Application by Norfolk Vanguard Limited ("the Applicant") for an Order granting Development Consent for the proposed Norfolk Vanguard Offshore Wind Farm and associated offshore and onshore infrastructure ("the Norfolk Vanguard project")

REQUEST FOR INFORMATION AND NOTIFICATION OF THE SECRETARY OF STATE'S DECISION TO SET A NEW DATE FOR DETERMINATION OF THE APPLICATION

Application by Norfolk Boreas Limited for the Norfolk Boreas Offshore Windfarm. Response to the applicants clarification note on trenchless crossings.

DATE: 31.05.19 SCALE AT A1: 1:250 CLIENTS REF: DRAWING No. TP-PB4476-DR033 REVISION: F1.1

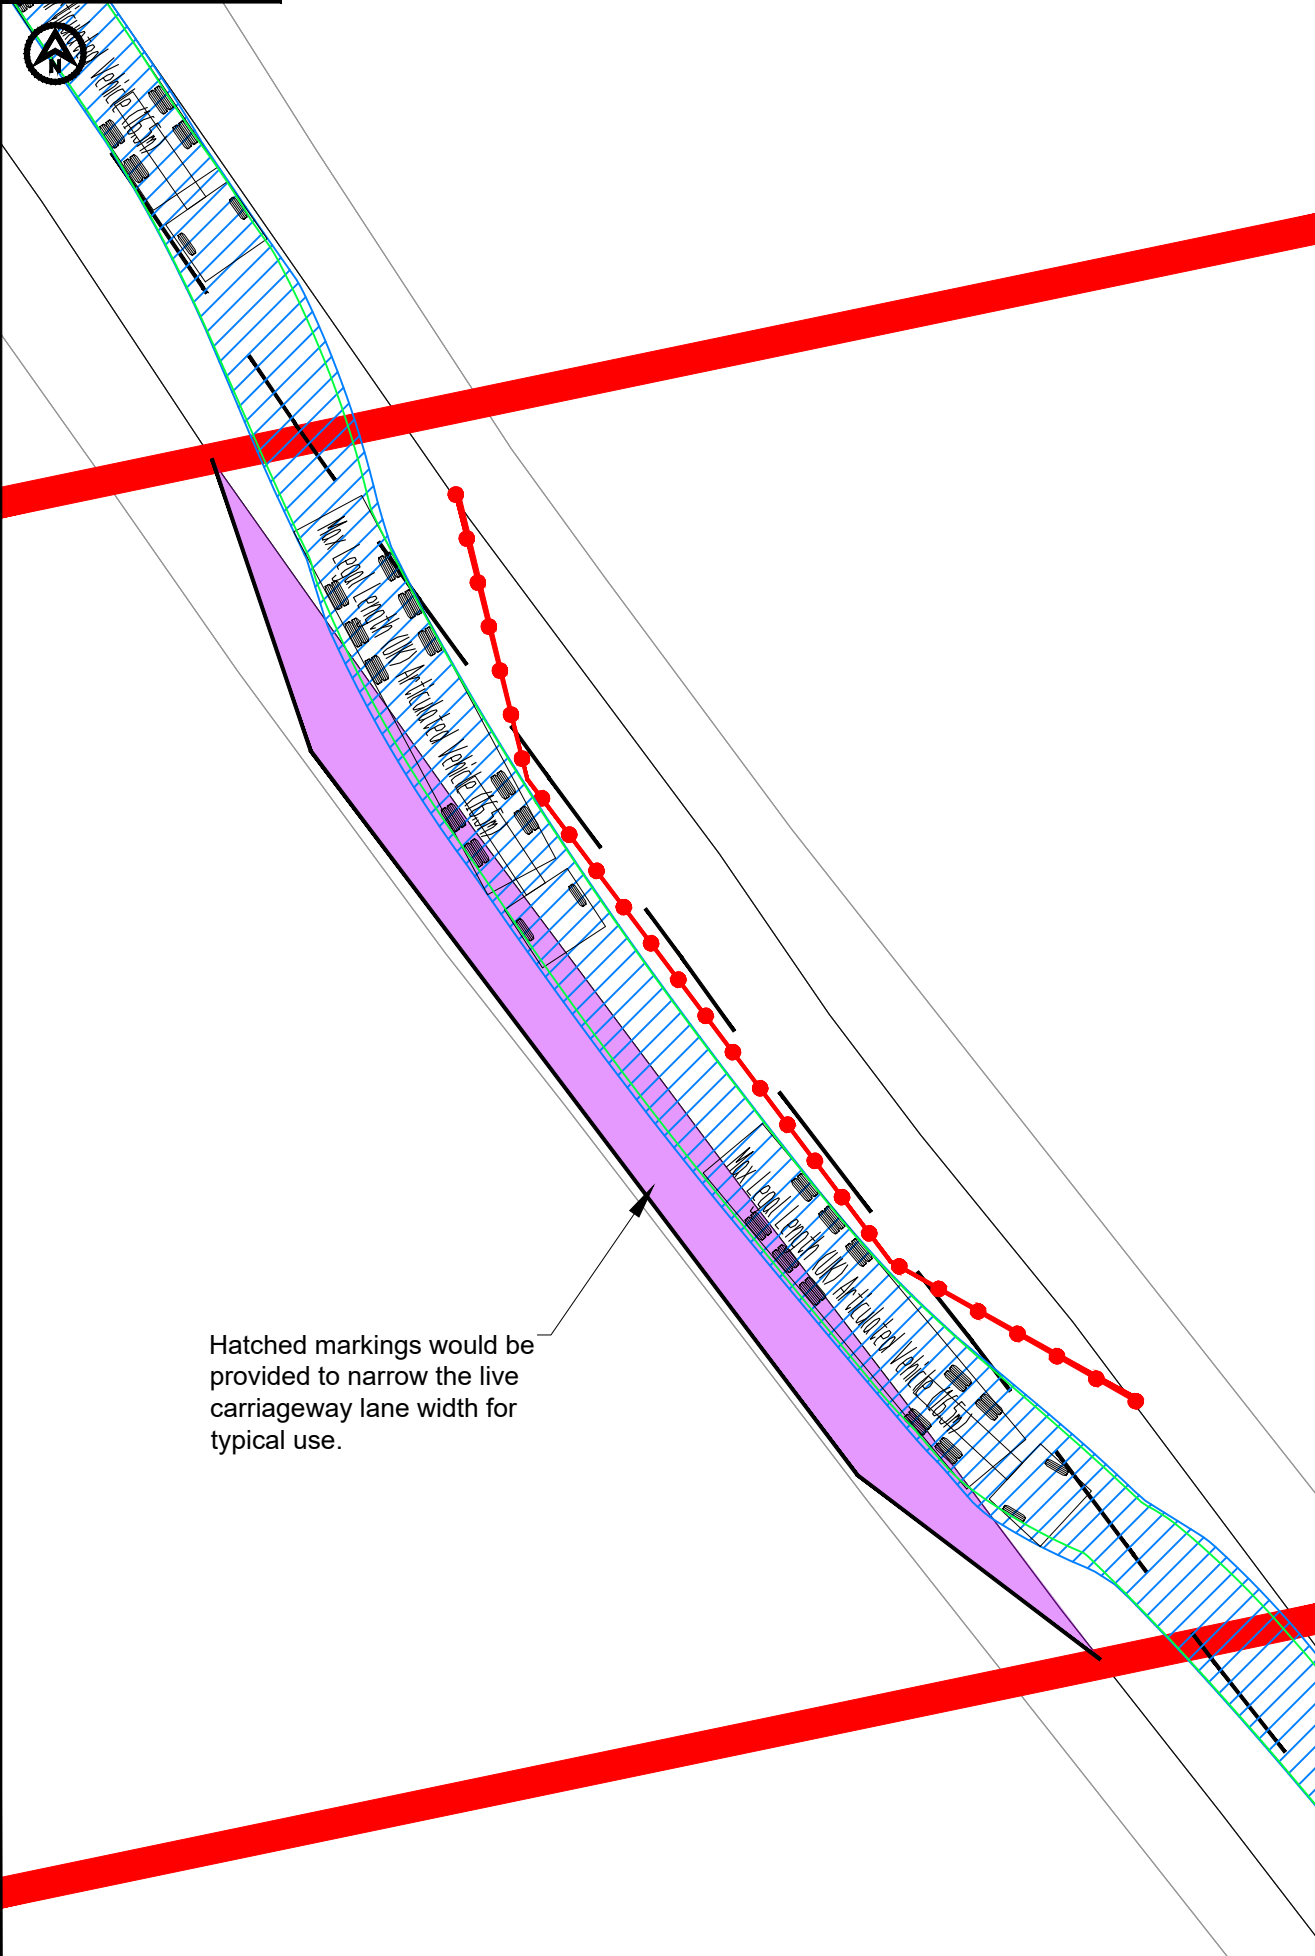
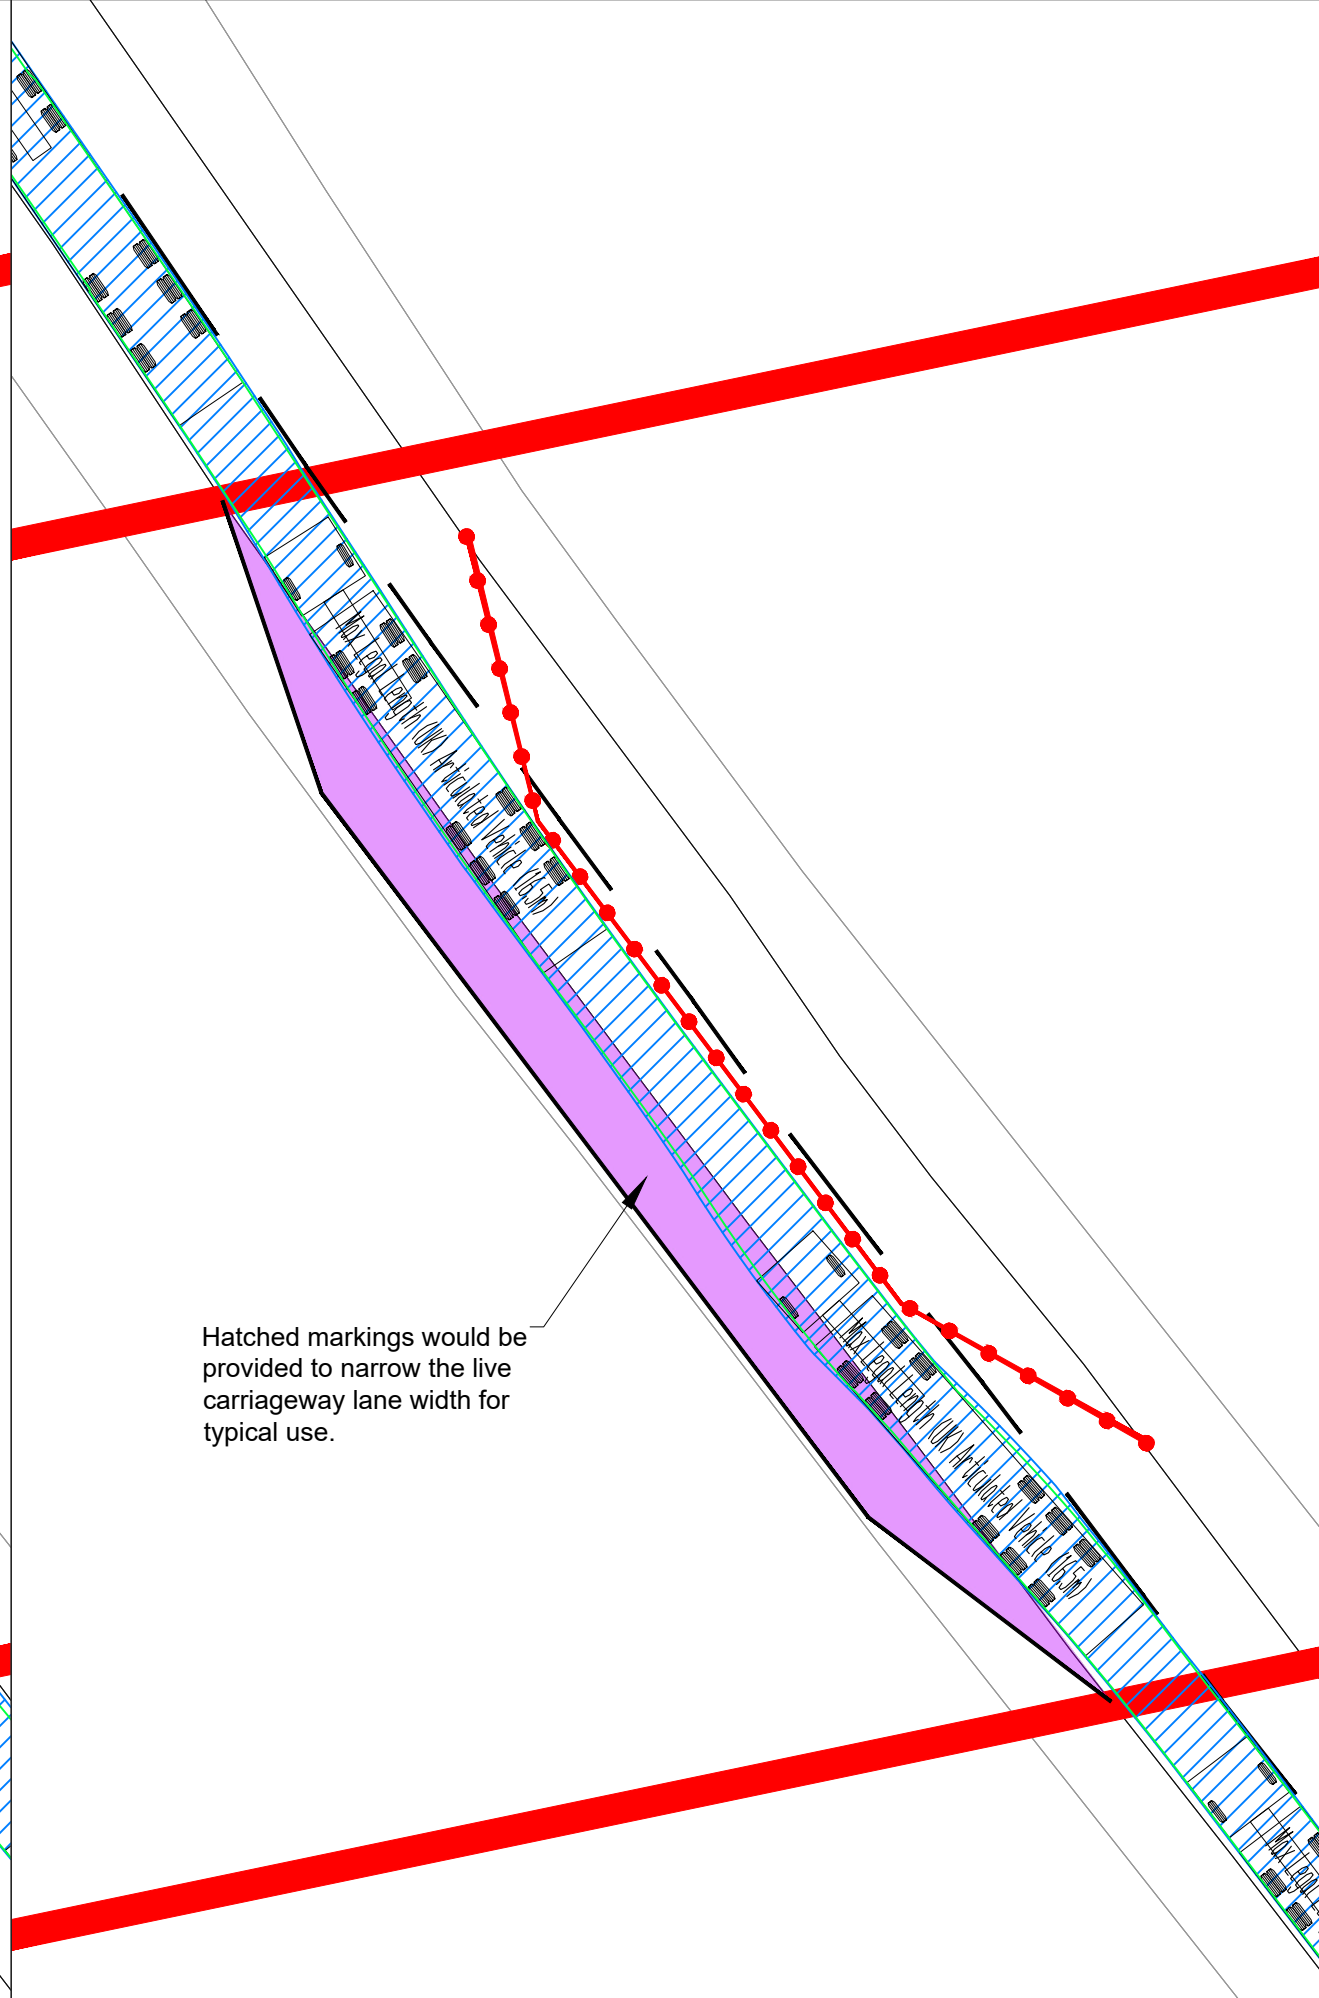
- This specific proposal would now require the construction of a new diversion lane (shaded pink on drawing numbers TP-PB4476-DR033 and TP-PB4476-DR036 attached to the applicants trenchless crossing clarification note). The disruption to road users for this specific proposal will be significant and last for weeks and not days as implied.

This specific proposal requires the construction of a new diversion lane as shaded pink on drawing numbers TP-PB4476-DR033 and TP-PB4476-DR036 attached to the applicants trenchless crossing clarification note. The disruption to road users for this specific proposal will be significant and last for weeks (see also our detailed comments under the heading timescale below).

Open cut trenching for this specific proposal to the B1149 will not only require the road to be dug up but also requires the highway verges and adjacent hedges (together with any trees) to be dug up and removed to accommodate a diversion lane (see area shaded pink on drawing numbers TP-PB4476-DR033 and TP-PB4476-DR036 attached to the applicants clarification note).

- Requires the highway verges and adjacent hedges and part of the field to be dug up and removed to accommodate a diversion lane. (see area shaded pink on drawing numbers TP-PB4476-DR033 and TP-PB4476-DR036 attached to the applicants clarifiacation note).
- Importing new raw materials to construct the diversion lane.
- Importation of granular back-fill for the deep excavation.
- The Outline Traffic Management Plan clearly indicates at para 45 that open cut trenching **would require a running track** to deliver equipment to the installation site from mobilisation areas and will require separate storage areas for topsoil and subsoil.
